Department of
Environment and Conservation (NSW)

Your reference :
Our reference : 282151A7:WOF13617:PW
Contact : Paul Wearne, (02) 4224 4100

**BLUESCOPE STEEL COGENERATION PLANT
PROPOSED SALT WATER COOLING**

DEC COMMENTS ON REPORTS SUBMITTED TO DATE

Bottom Layer

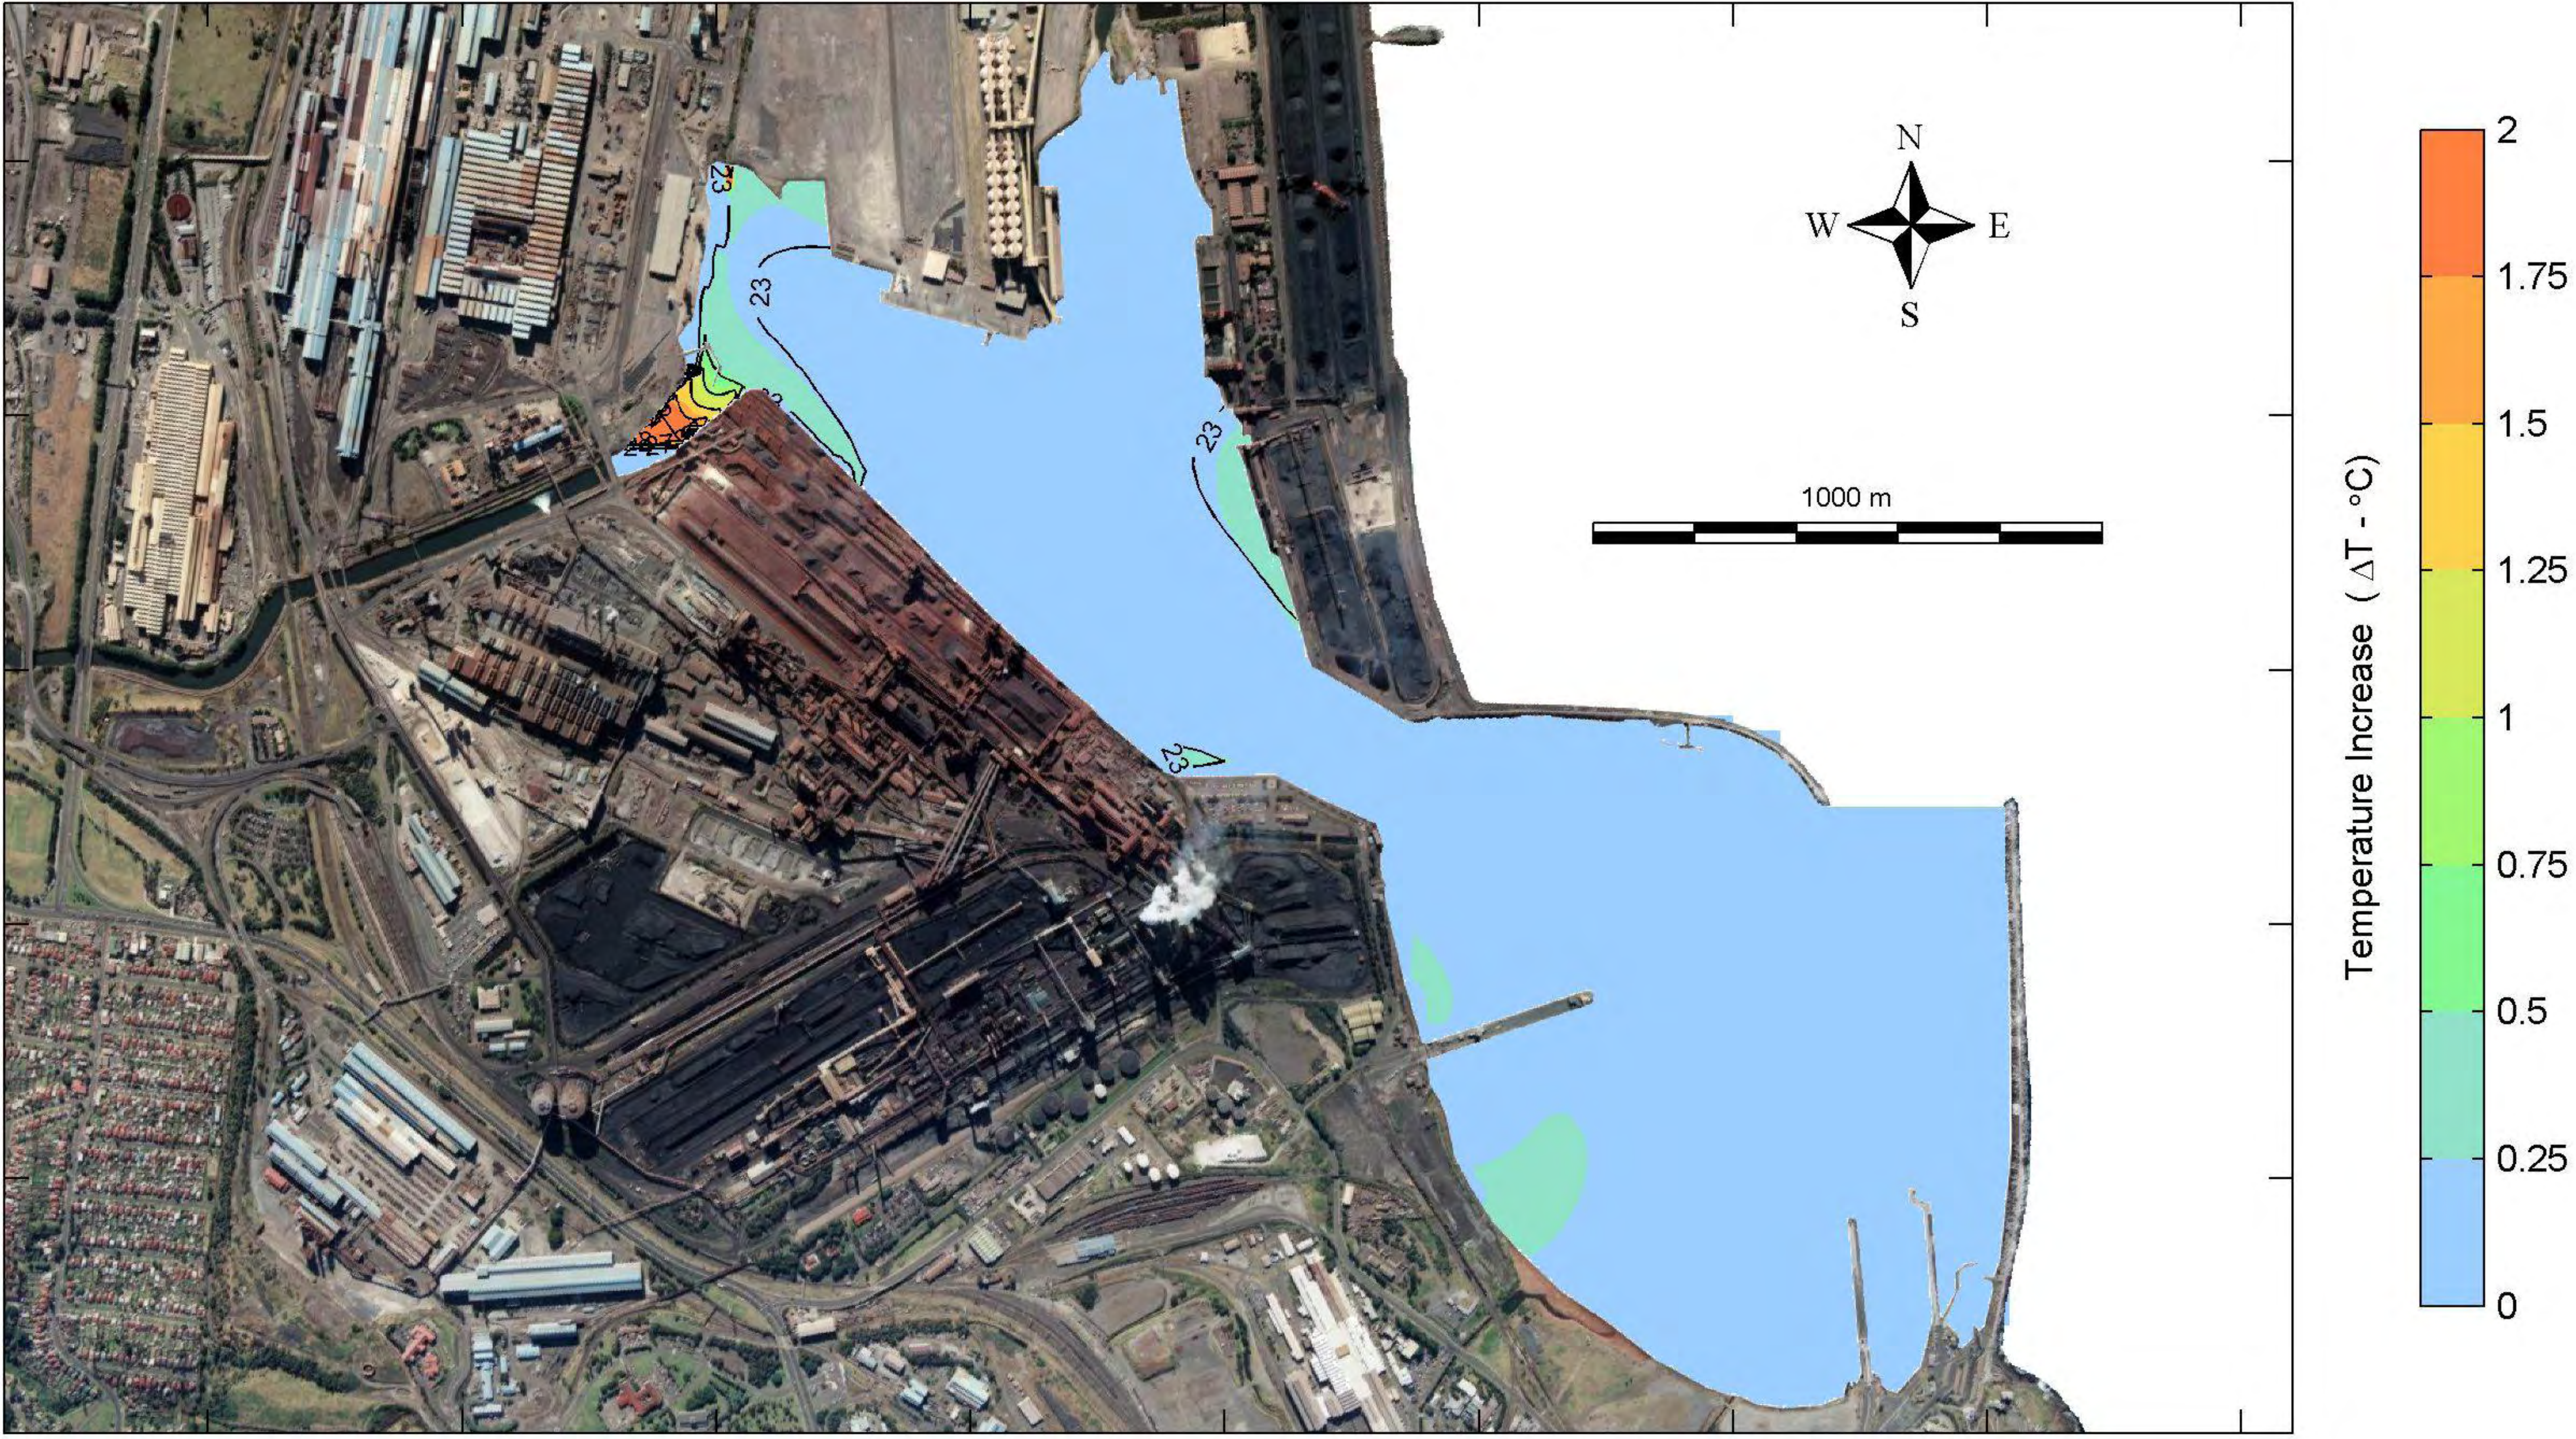
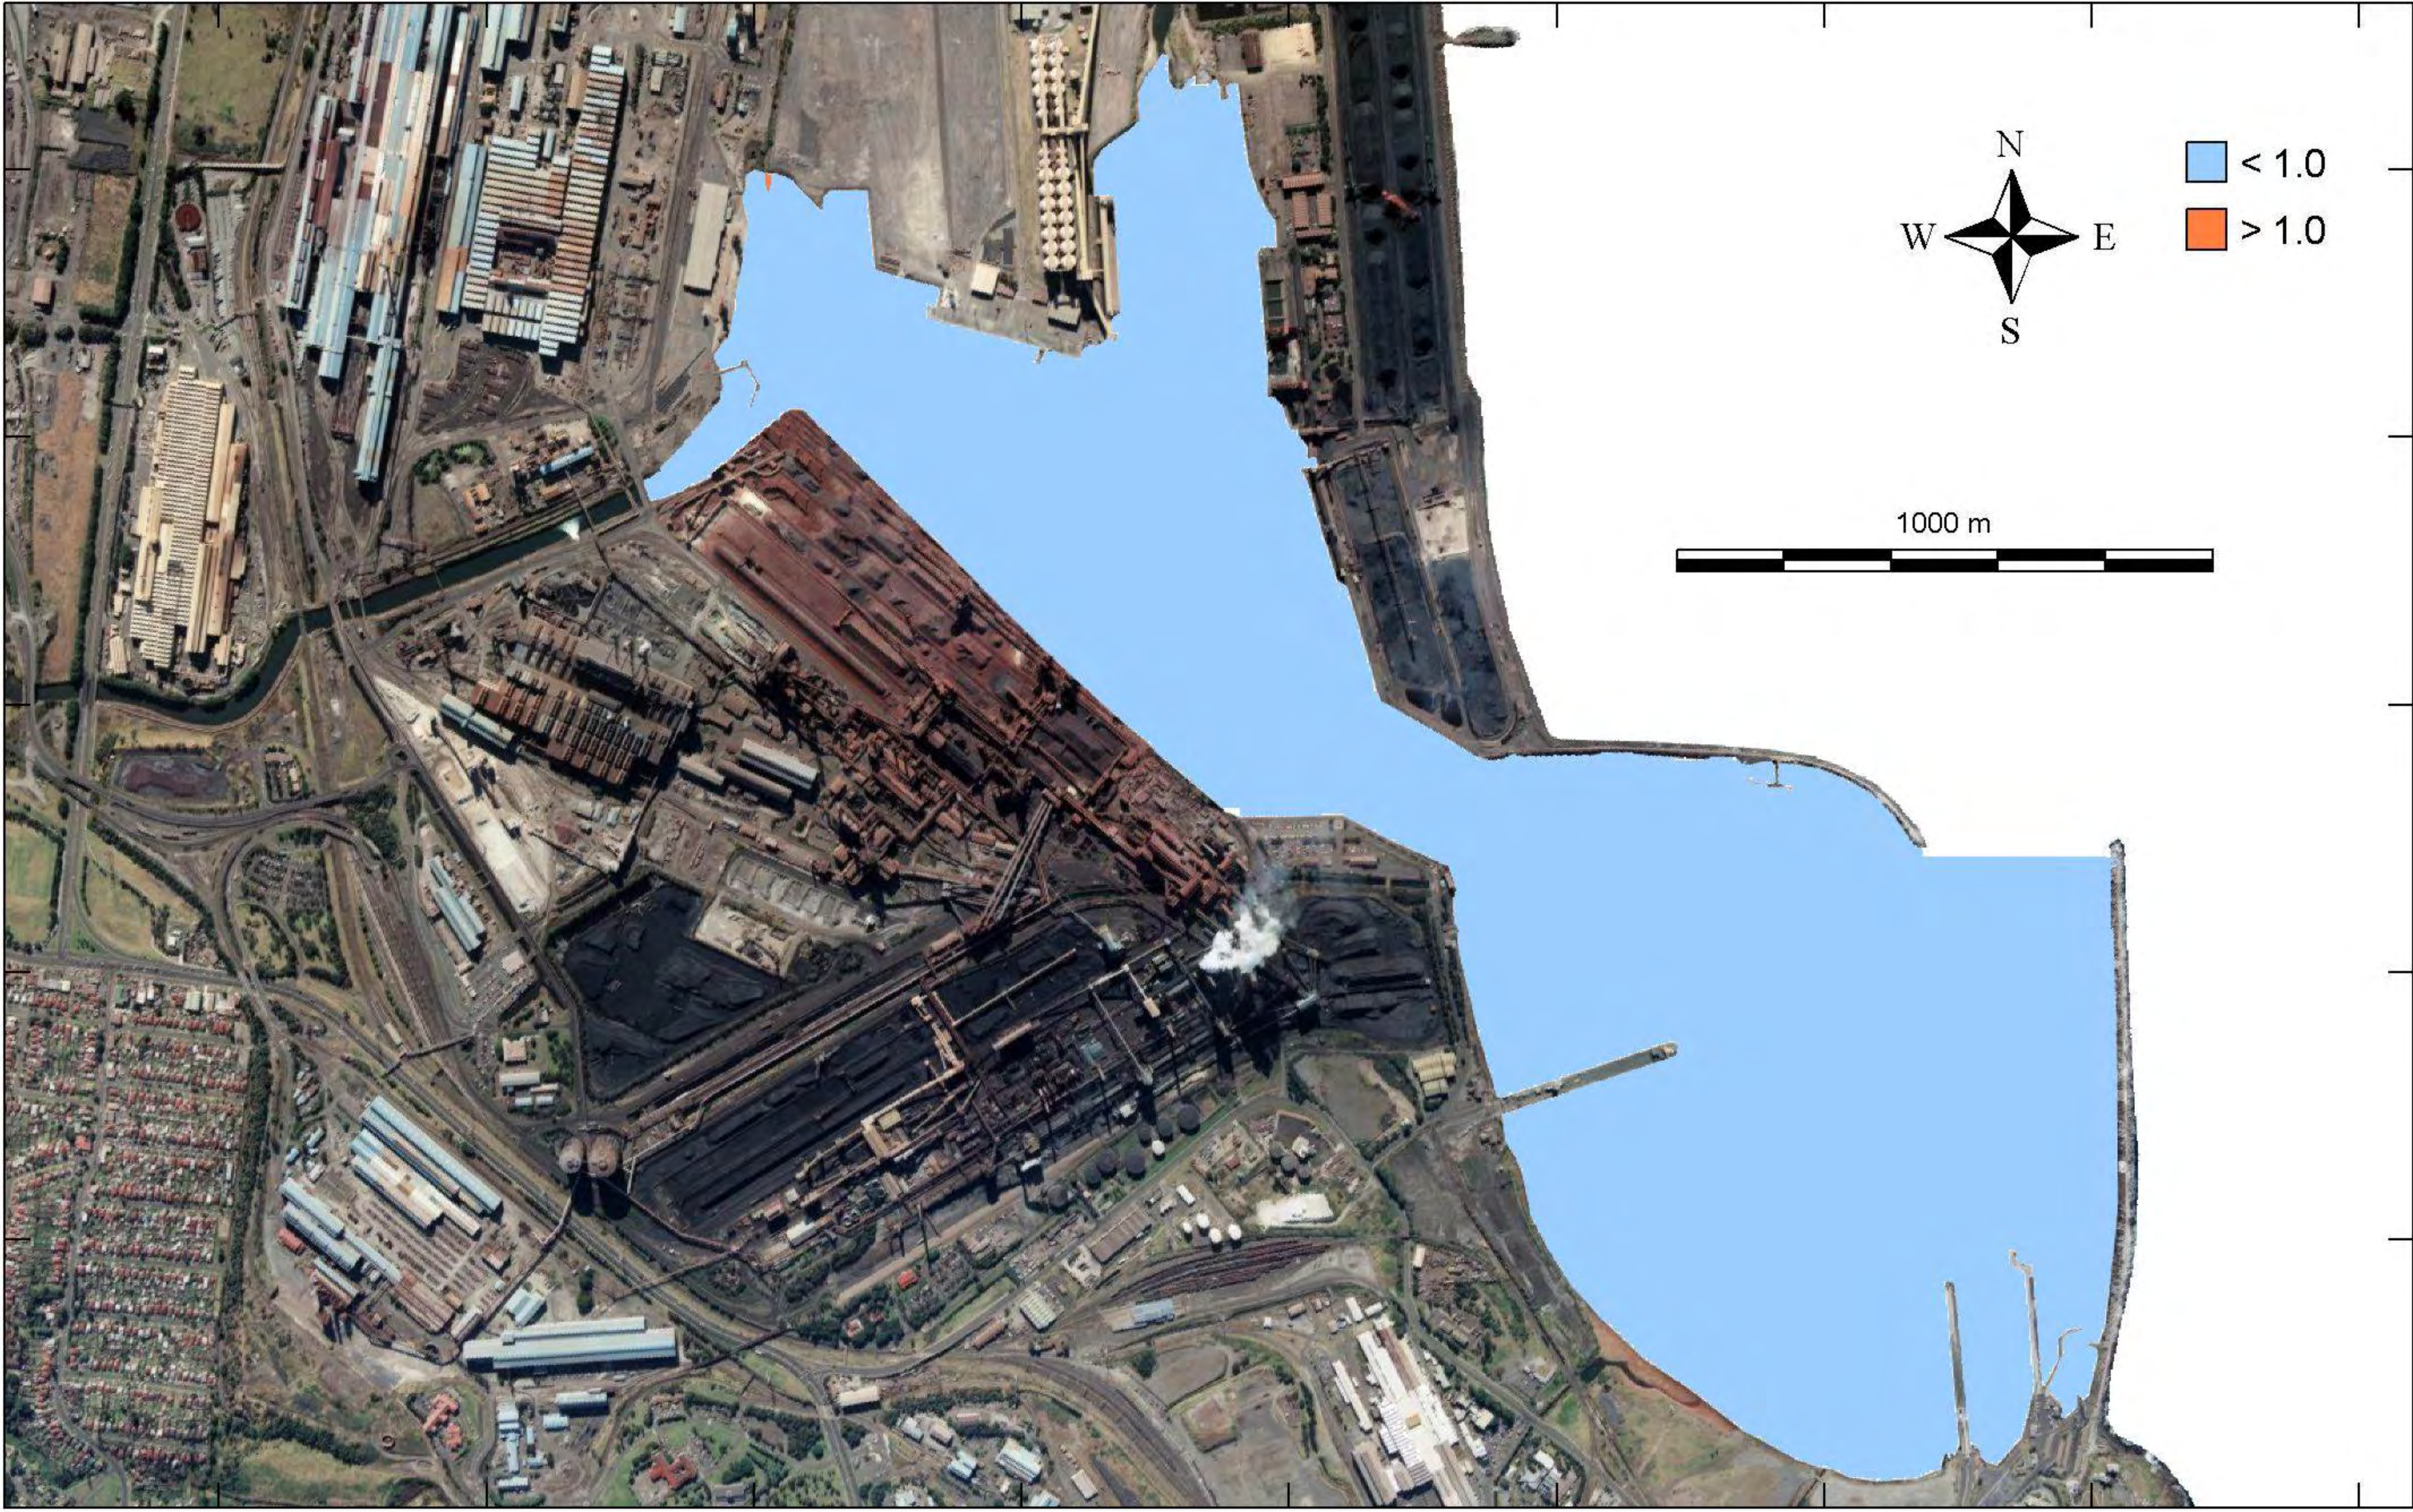
Model scenarios should describe a set of worst case conditions (from an environmental perspective) as well as typical conditions. Modelling investigations must, therefore, include simulation of average daily and maximum heat loads for all seasons including winter when temperature increases may be greatest due to cooler receiving waters (existing modelling focused on the period from 1st Jan to 28th Feb when the heat load is expected to be greatest).

Results of modelling scenarios should also be presented as differences between water temperatures with and without the thermal loading in order to illustrate the extent of the thermal disturbance above ANZECC (2000) trigger criteria. That is, the simulated 50th percentile temperatures must be compared with 80th percentile natural ambient temperatures. This analysis can be undertaken for a summer period (e.g. 1st Jan to 28th Feb) and an equivalent winter period when ambient water temperatures are at a minimum.

The adoption of 22.5°C as the boundary temperature condition must be substantiated.

It will be necessary to verify the model against observation of actual water temperatures across the modelling domain. Any existing verification data for the current discharge should be presented to validate the model which will be used for assessment of proposed discharges.
